From: [REDACTED]
Sent: 25 January 2026 10:26
To: Planning
Subject: App 3/2025/0861 Burnhouse Farm Back Lane Slaidburn - Ecology Unit Response

App 3/2025/0861 Proposed construction of No.3 camping lodges and a utility hut including associated hardstanding and landscaping, Burnhouse Farm Back Lane Slaidburn

Burn House Farm
Back Lane
Newton-in-Bowland
Clitheroe
BB7 3EE
BNG Map
October 2025

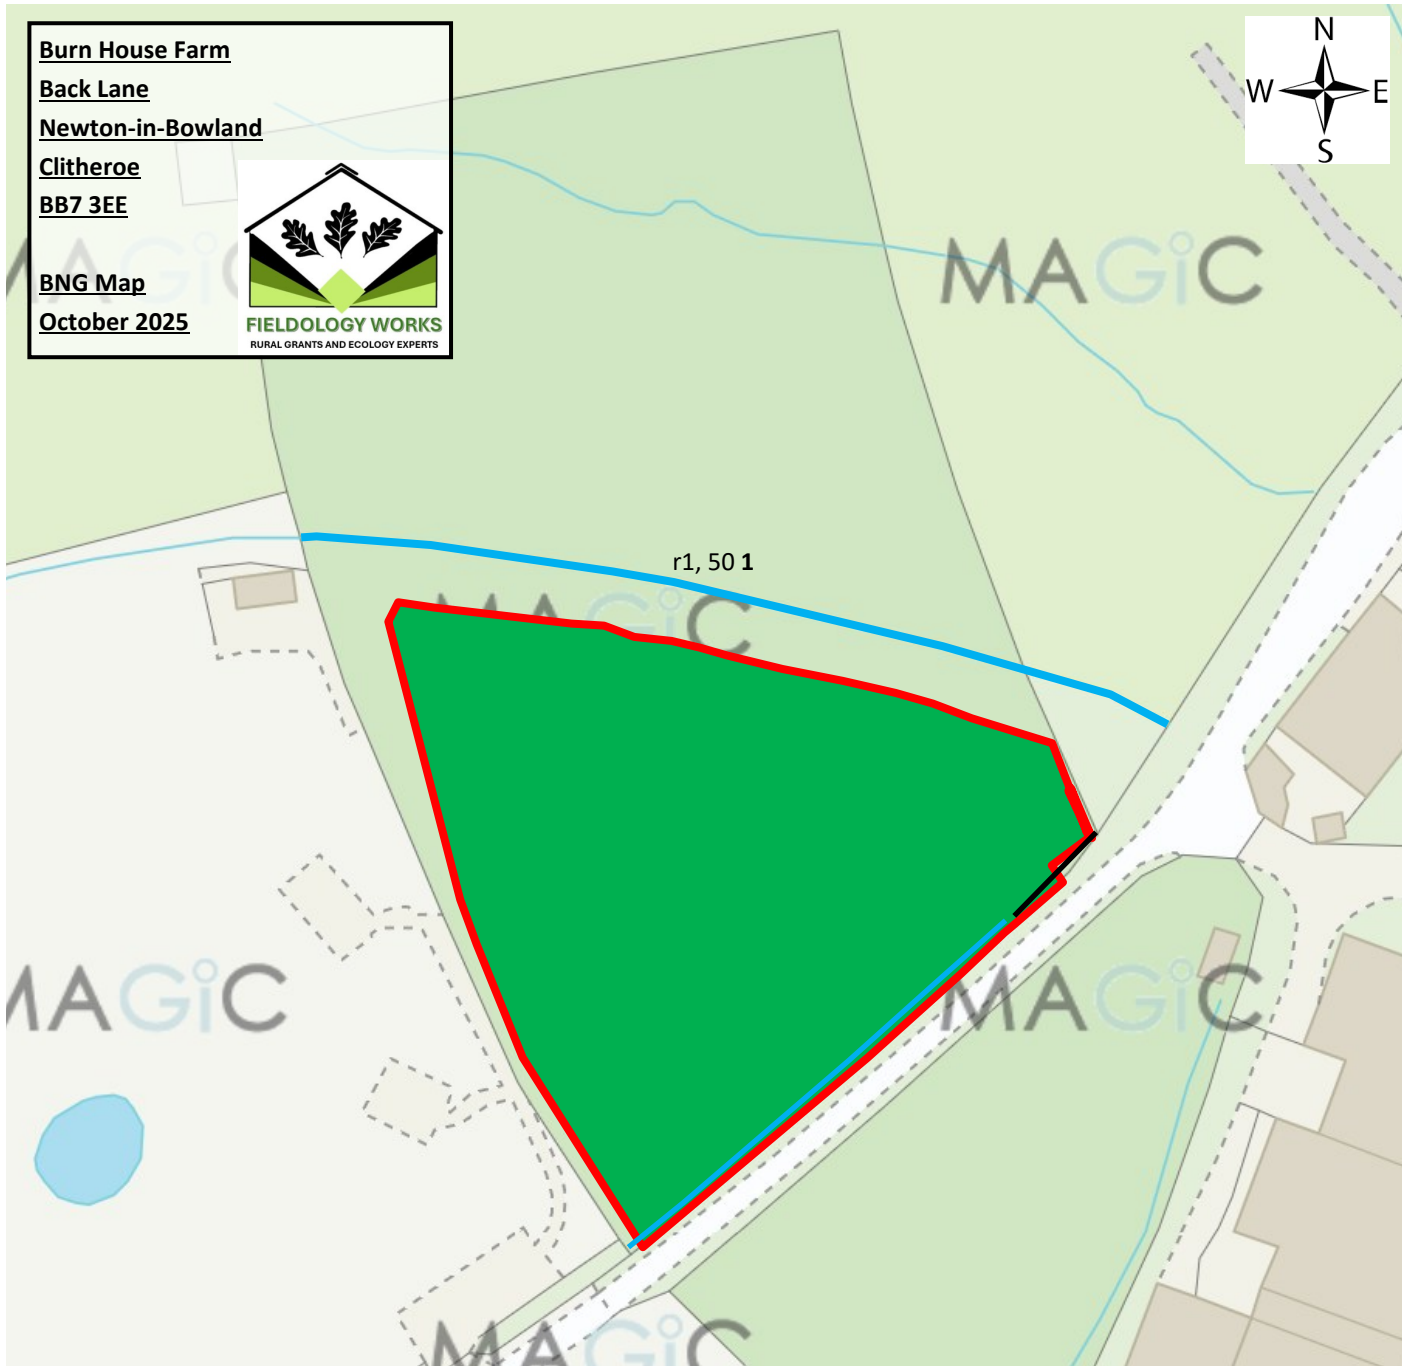
- There are some small discrepancies between the baseline habitats recorded on the site in the biodiversity metric and the baseline habitats recorded in the preliminary ecological appraisal (PEA); the metric has described the whole application site as mixed woodland, while the PEA has also recorded smaller areas of scrub and grassland habitats. Given that habitat types present other than woodland represent small areas not as directly affected by the development as the woodland, I would not regard these discrepancies to be significant, but I would advise that the statutory Biodiversity Gain Condition will apply to any permission which may be granted to the application, to require the pre-commencement submission of a final, comprehensive Biodiversity Gain Plan (BGP). As part of the BGP a final, comprehensive Biodiversity Metric will be required describing impacts on habitats in full. I would accept that the required biodiversity gain could be delivered on-site through new habitat creation and

habitat enhancement. A 30-year Habitat Management and Monitoring Plan should also be required by Condition. Since the on-site habitat provision would be significant the implementation of this Plan will also need to be secured by an S106 agreement or by Condition
